Application No: R/60/22/PL
Site Address: The Windmill Inn Mill Lane Rustington BN16 3JN
Description of works: Extension and remodelling of existing public house to form hotel with 20 No bedrooms and associated parking and landscaping. This site is in CIL Zone 4 (Zero Rated) as other development.

Thank you for your internet representation made on 1st April 2022 which has been recorded as an objection with the comments as follows:

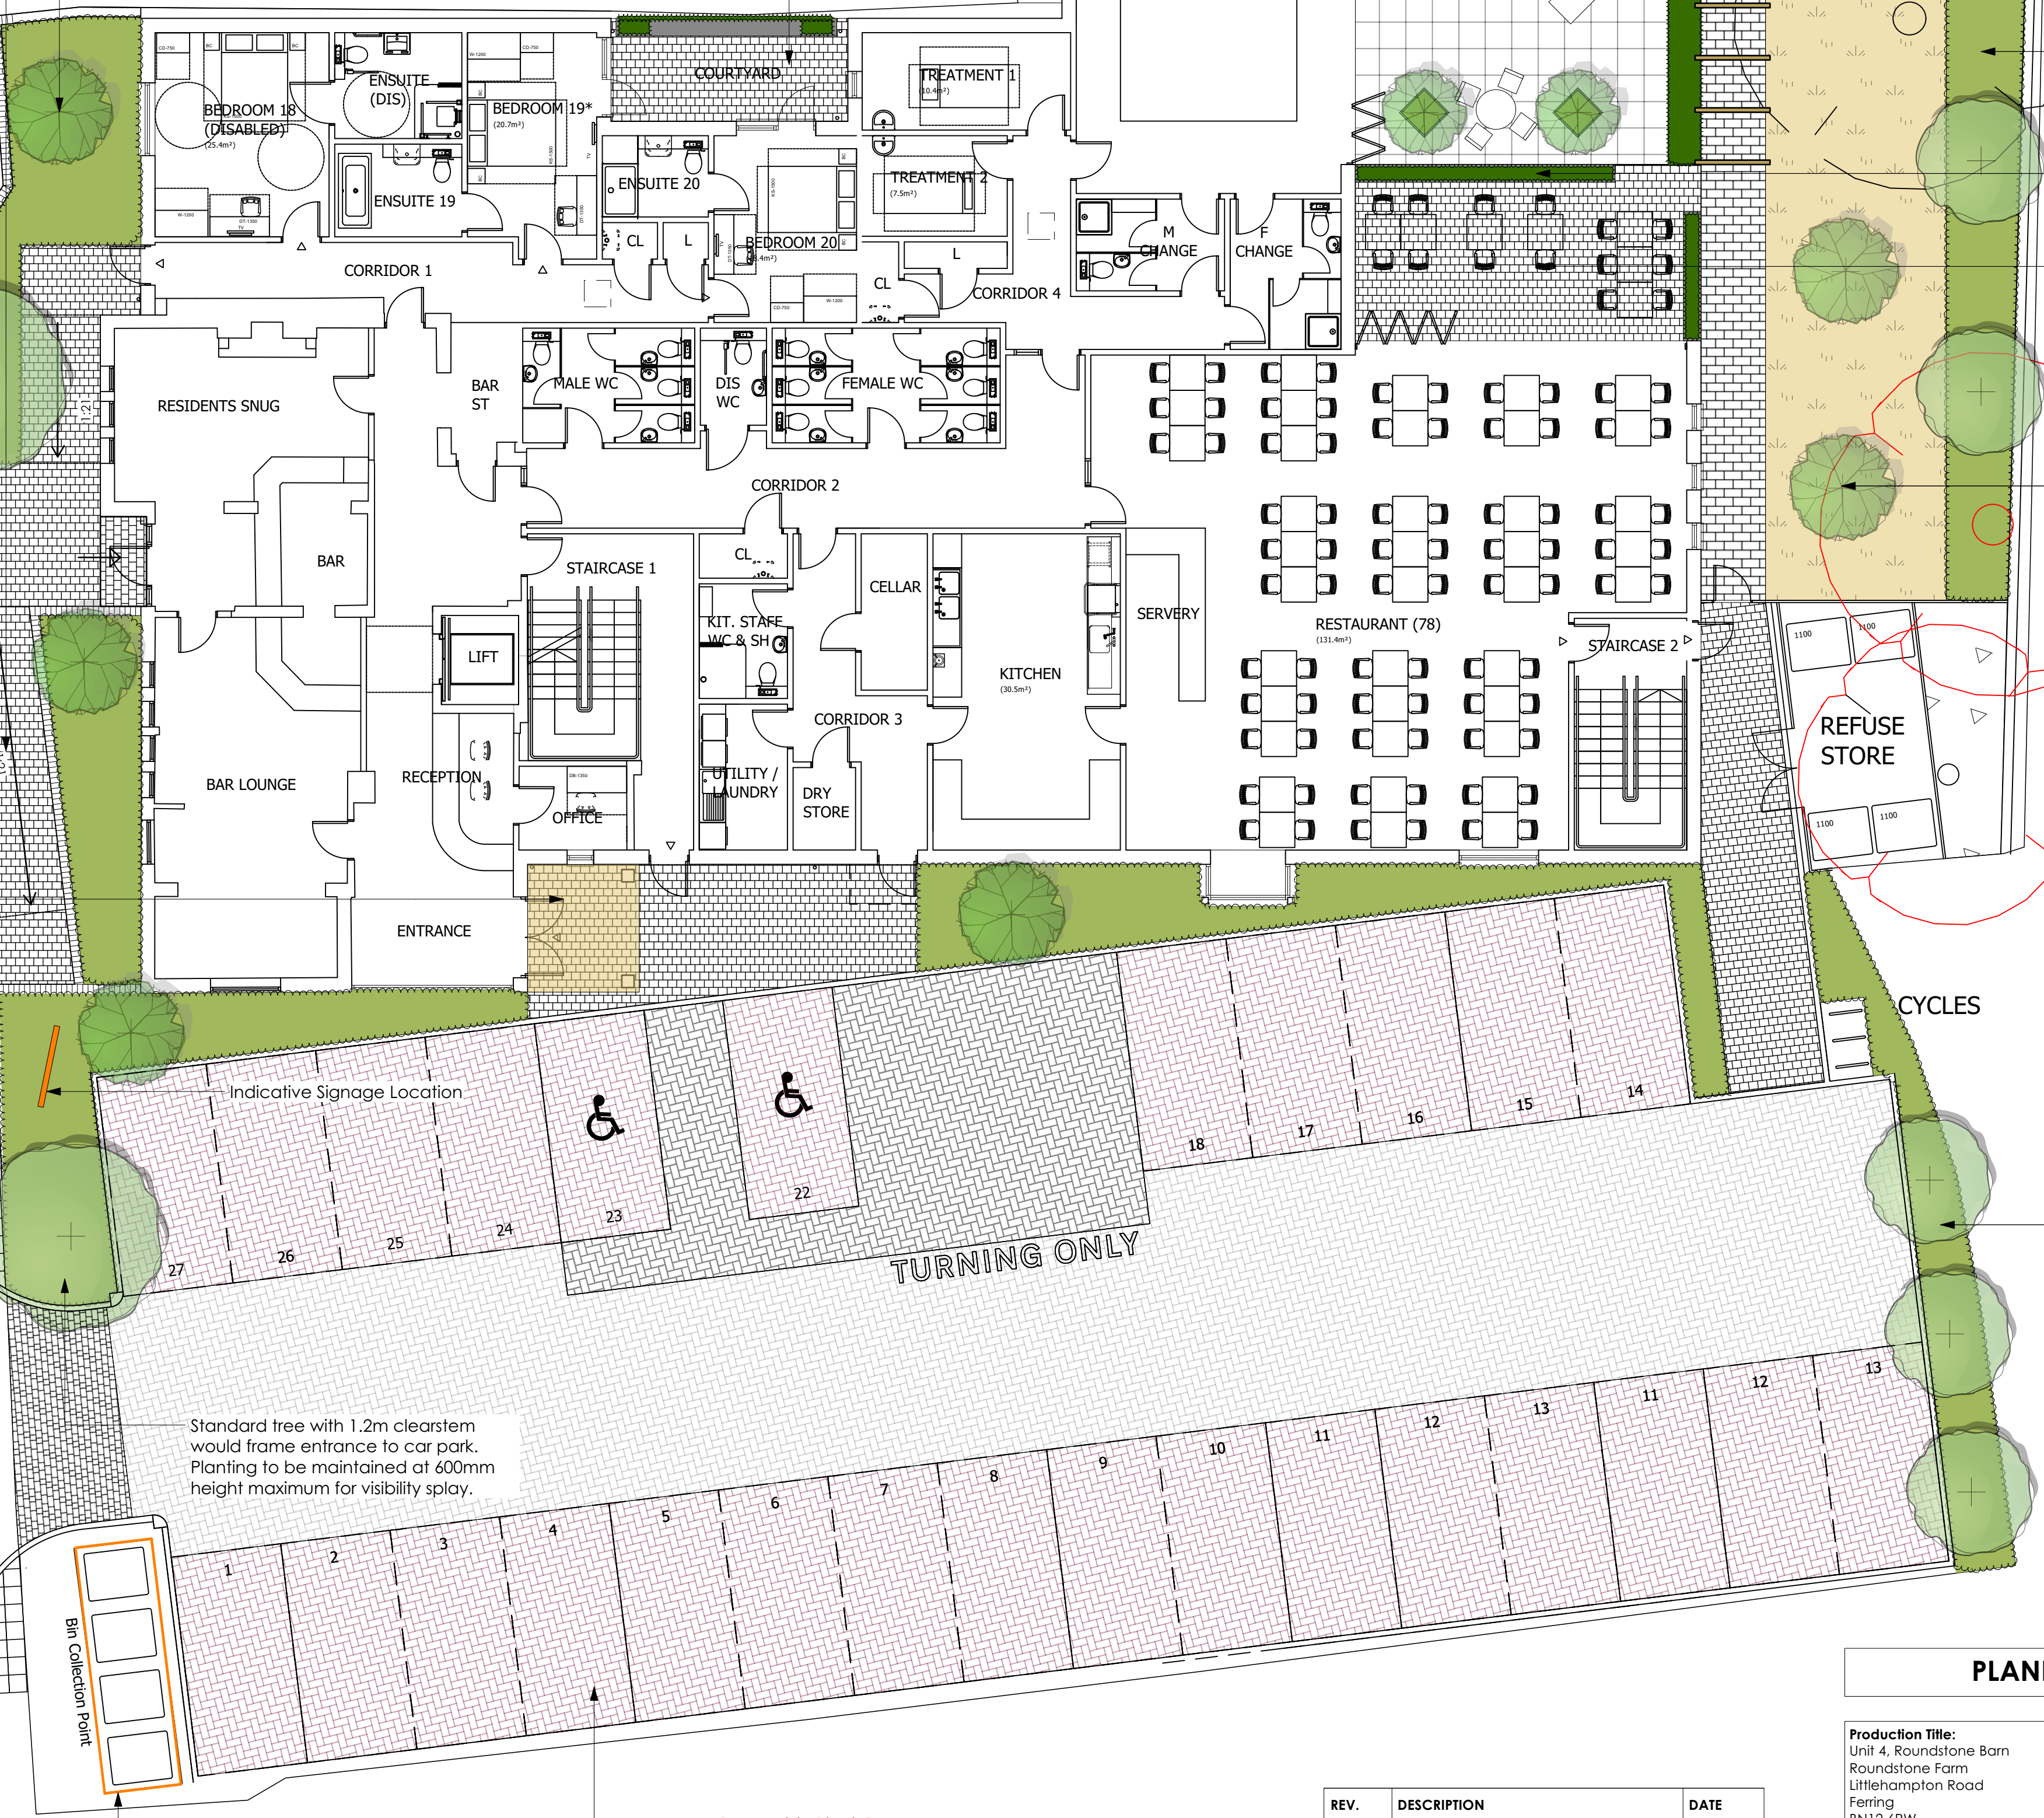
Landscape Strategy Master Plan and DAS Statement 9.00 Landscape and Ecology.

This shows trees T1 and T2 will be removed to allow space for a refuse store "yes a refuse store" you read that correctly, not a good swap. This store could easily be combined within the bin collection store at the front of the site, away from the restaurant seating, path to garden and nearer to where the majority of the waste will be produced.

Currently T1 & T2 will act as a screen to the proposed large development that is finishing very close to the rear boundary, making it less of a major impact to those people living in Fircroft Crescent.

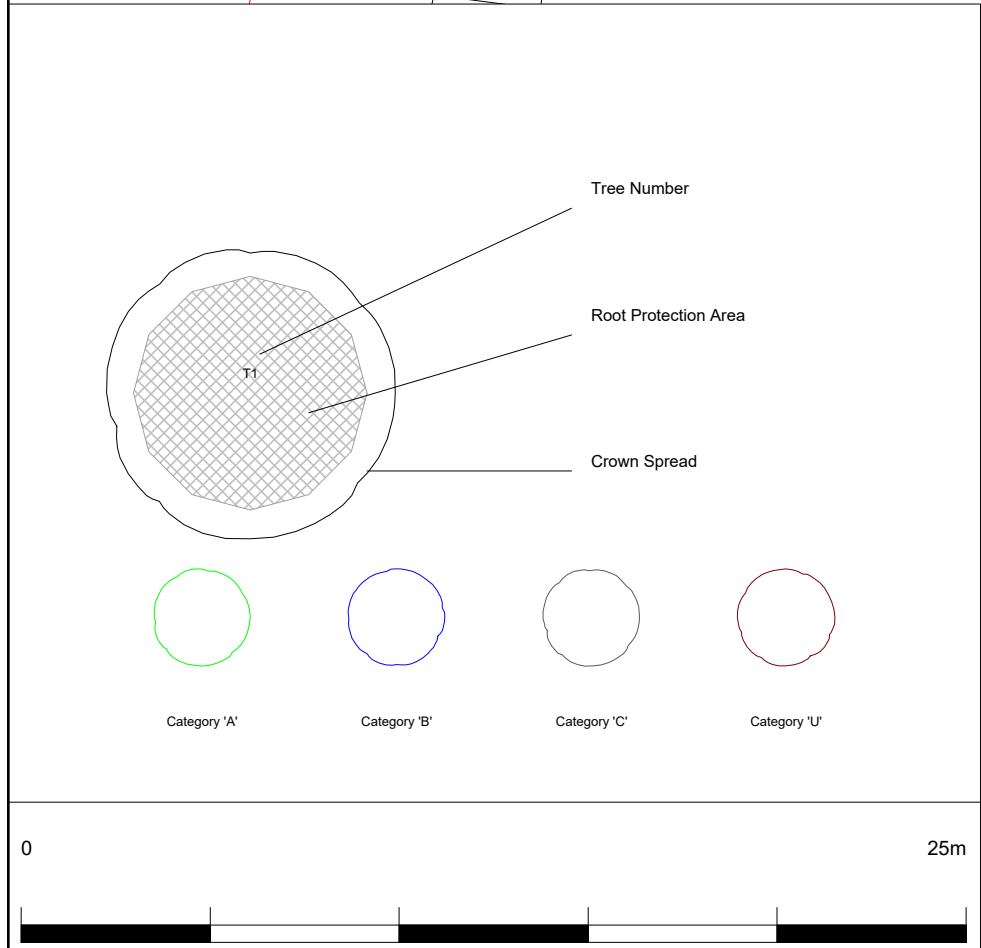
Arboricultural Report 3.8.1

I am surprised that in this day and age 2 mature trees T1 & T2 that with proper management could last 20 years are going to be removed. The Report states there are no trees recommended for removal within the proposal. However, trees T1 & T2 next to the car park could be considered for removal to allow better site access and to the garden after completion. These trees are right at the back of the site on the rear boundary and do not and will not interfere with access to anything.

I suspect removing these trees is solely a cost issue relating to the foundation depth required if they remain and future Building insurance requirements, removal of these mature trees should not be allowed...
